From: Contact Centre (CRM) <contact@ribblevalley.gov.uk>
Sent: 22 June 2026 17:28
To: Planning
Subject: Planning Application Comments - 3?2026/0401 FS-Case-850109885

Planning Application Reference No.: 3?2026/0401

Address of Development: 5 New Row Cottages, Clitheroe Road, Knowle Green PR32YS

Re : Planning Application No 3/2026/0401

EXISTING ELEVATIONS

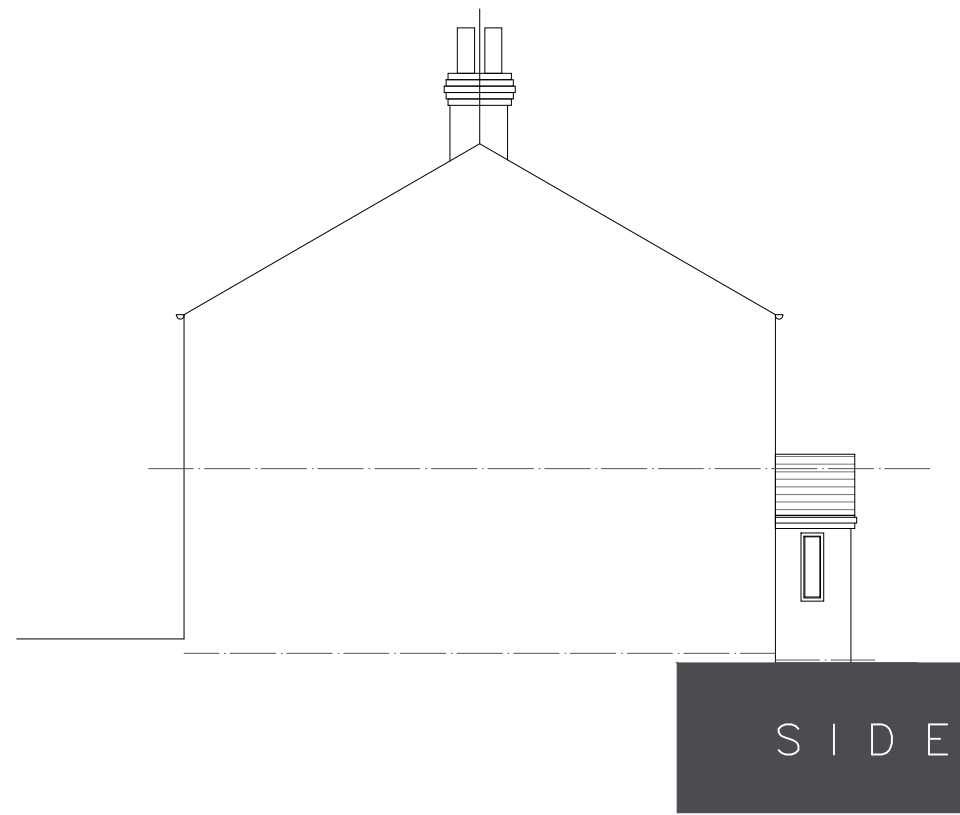
1 The proposals include the demolition of the existing porch and erection of a larger one both width and height wise (although the finished depth will remain unchanged) The existing front elevation shows the roof of the porch to be currently at a height of 2723 mm at its apex and the roof structure is replicated by every other porch along this row of what are traditional stone terraced weavers cottages.

PROPOSED ELEVATIONS

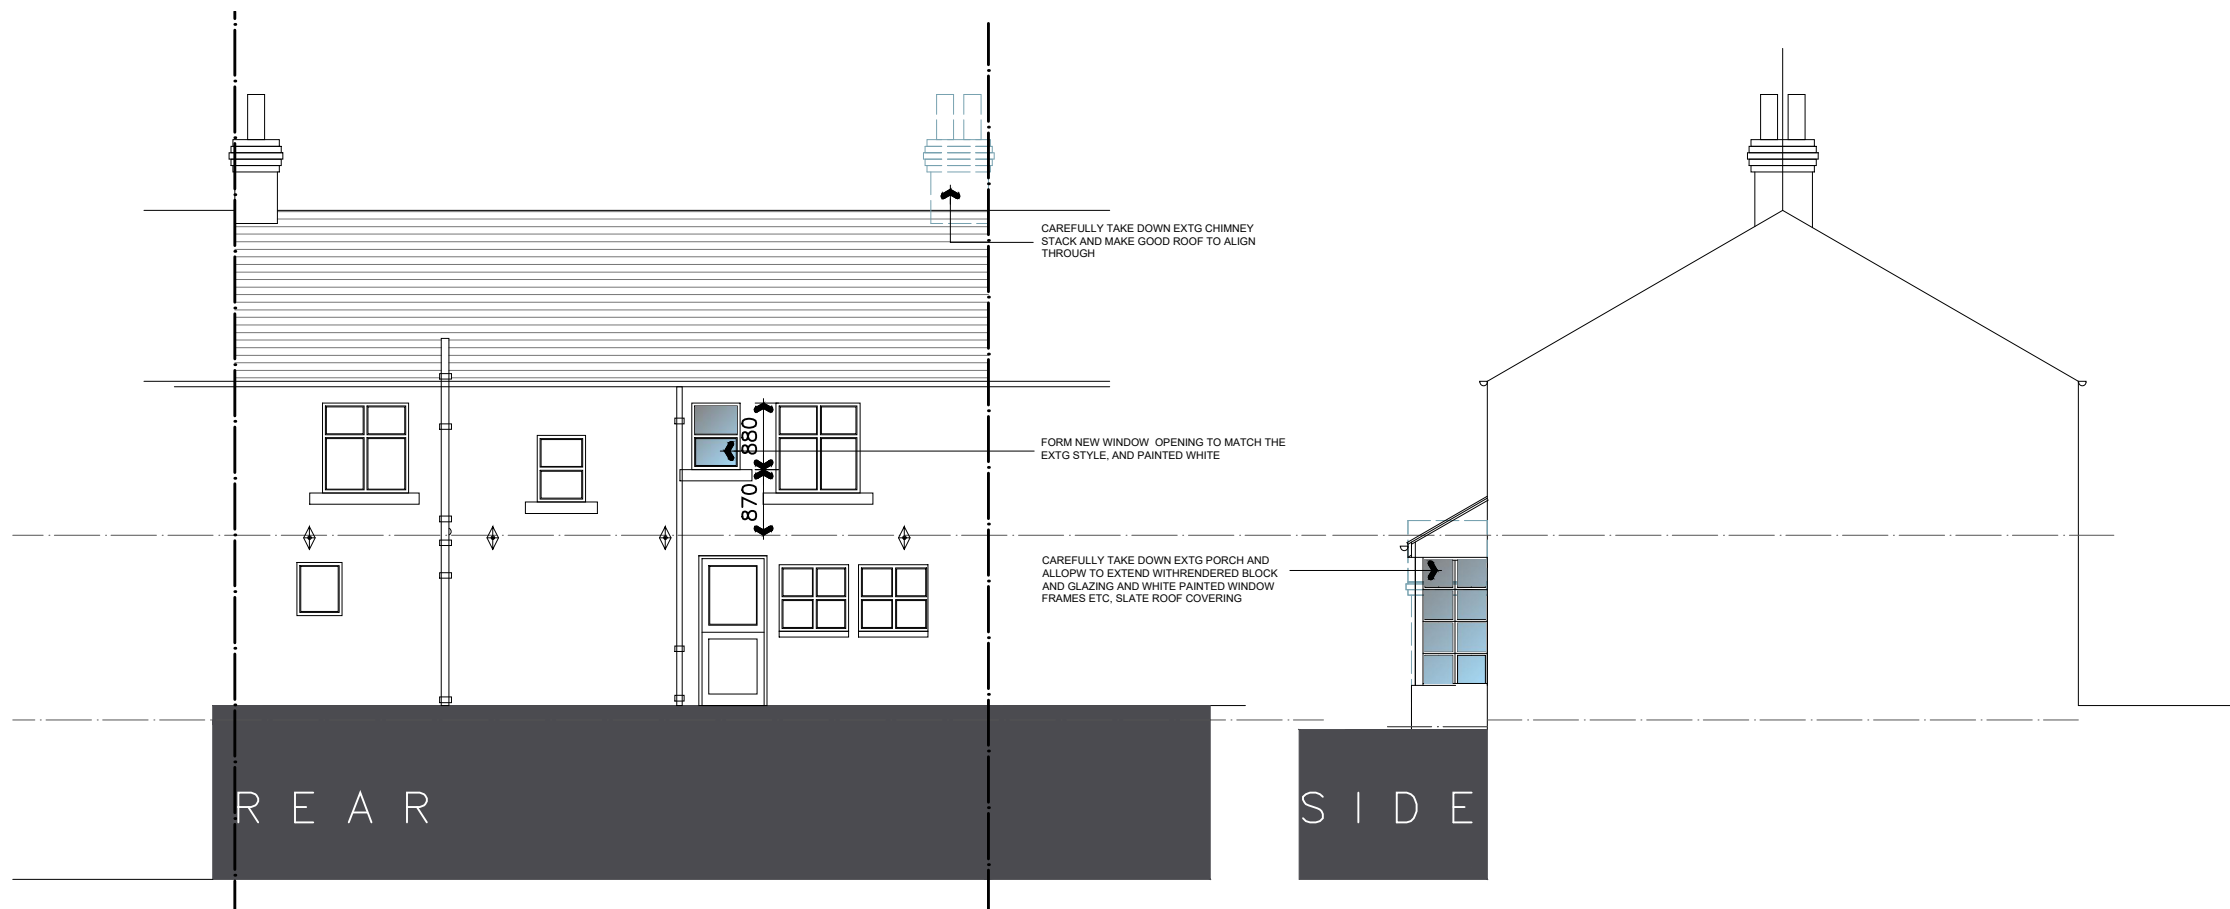
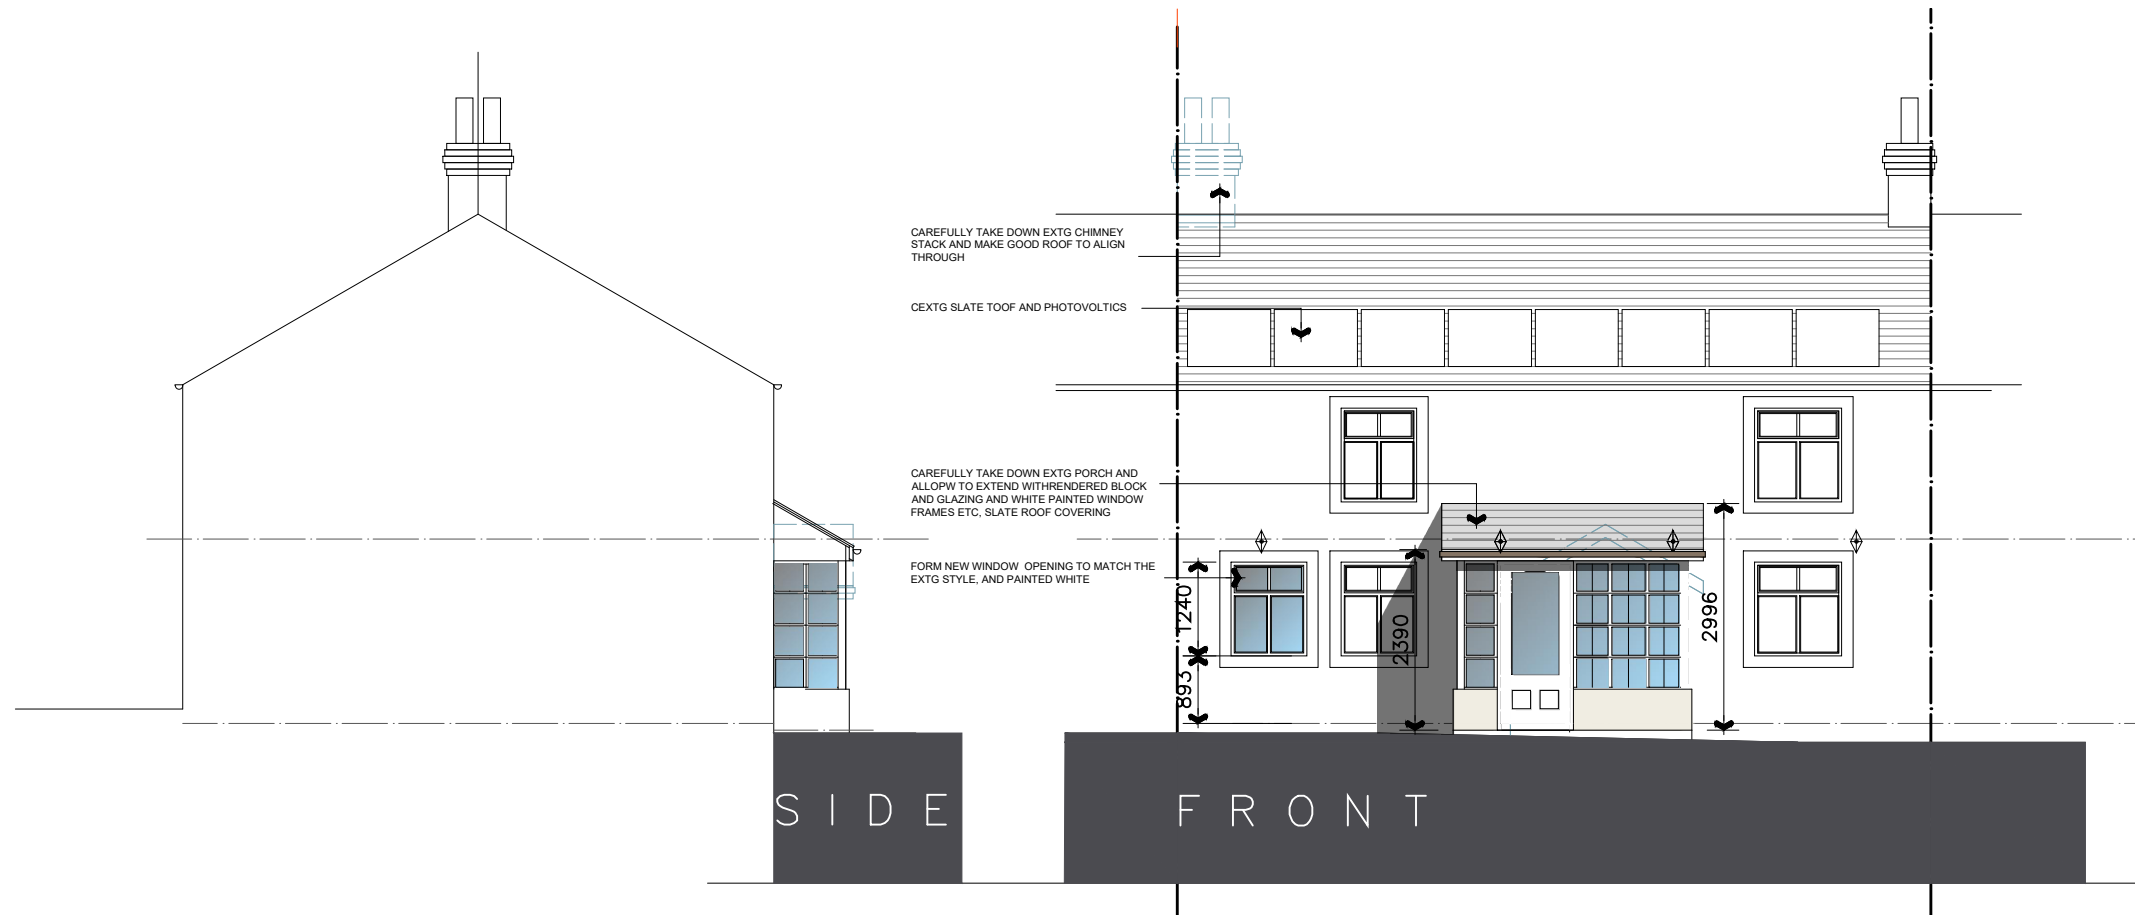
The new design is not in keeping with so much glass and the style of the roof and does not seem appropriate for such a lovely row of cottages.

The proposed erection of a larger porch with a pitched roof of 2996 mm where it adjoining the front house wall will be as high as the upstairs window sills. This together with the more glazed frontage we feel will be out of keeping with the other properties along the row and the extended width and height will be a dominate feature at the front of the cottage which is in a central position in the middle of the

PROPOSED PLANS

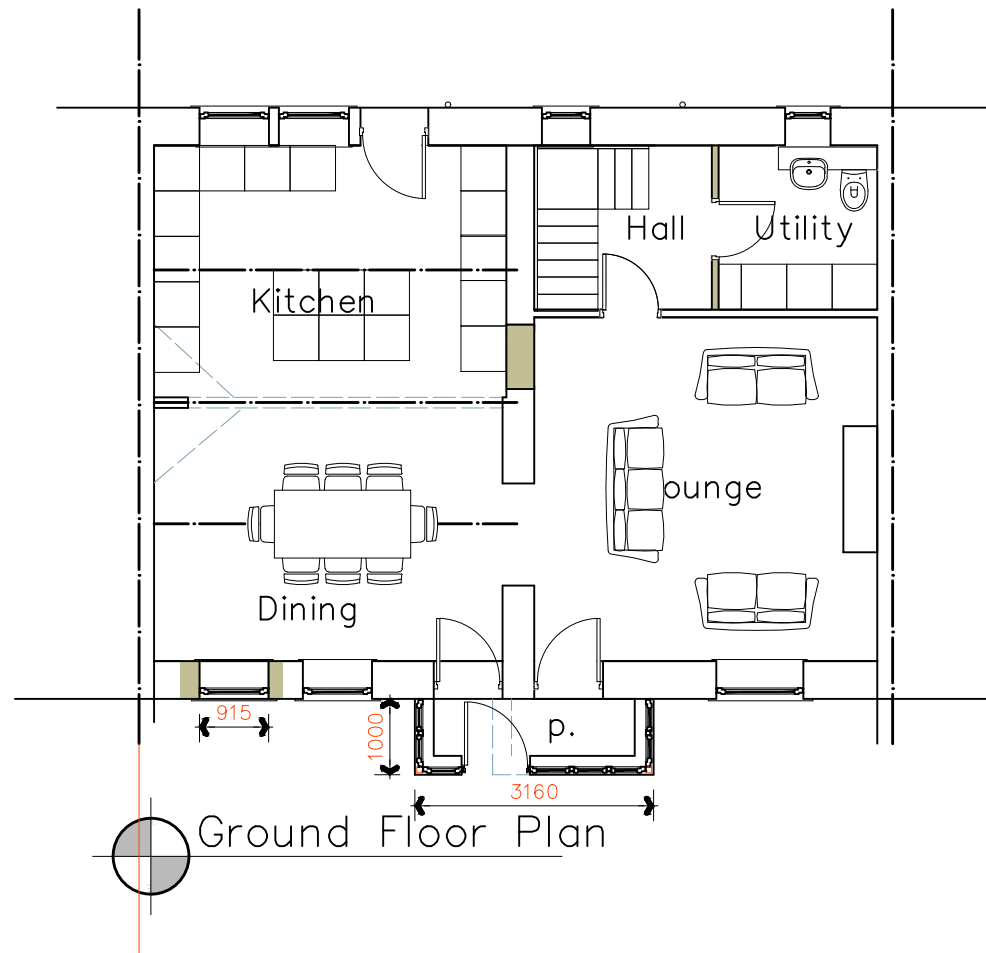
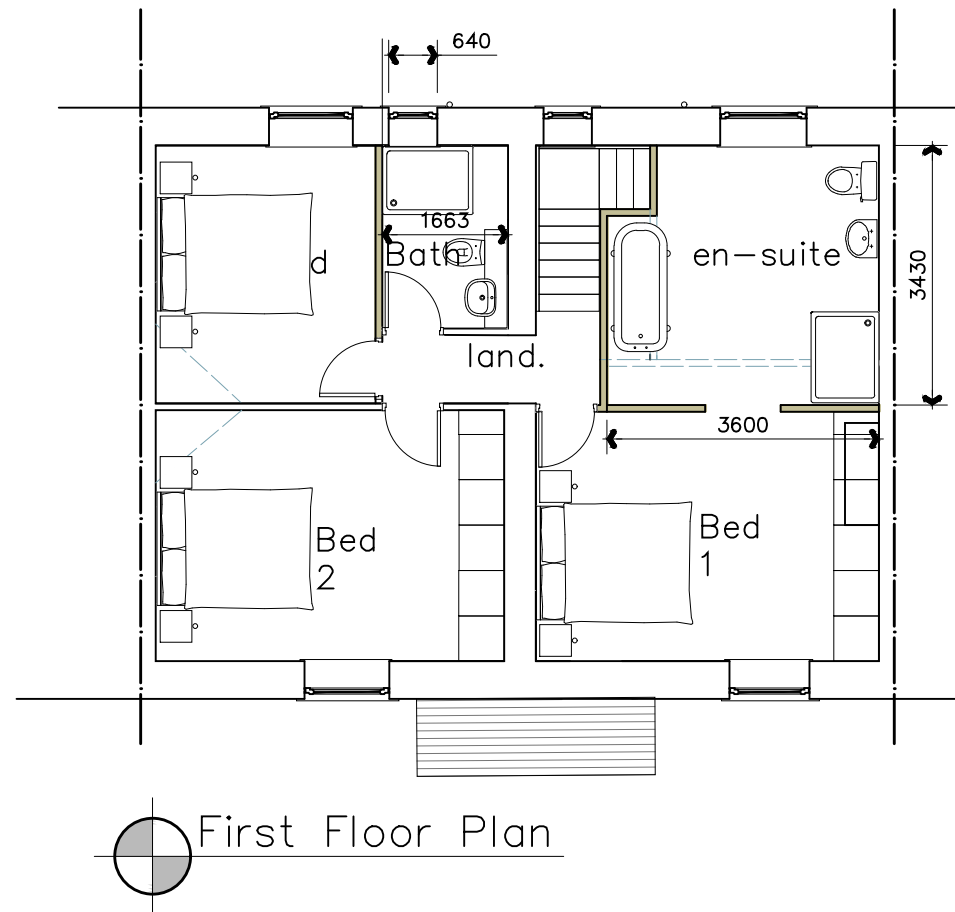
2 Regarding the changes to the internal upstairs bathroom we should like to point out that it is proposed that the shower, wash hand basin and toilet are to be

is not always necessary it is
With regard to noise from running
water and flushing toilets we would like to be assured that any pipe work is not channeled into the wall itself and that adequate noise insulation is installed. It is necessary that both of these conform to UK Building Regulation (G, H, E) and they will need to have Building Control approval.
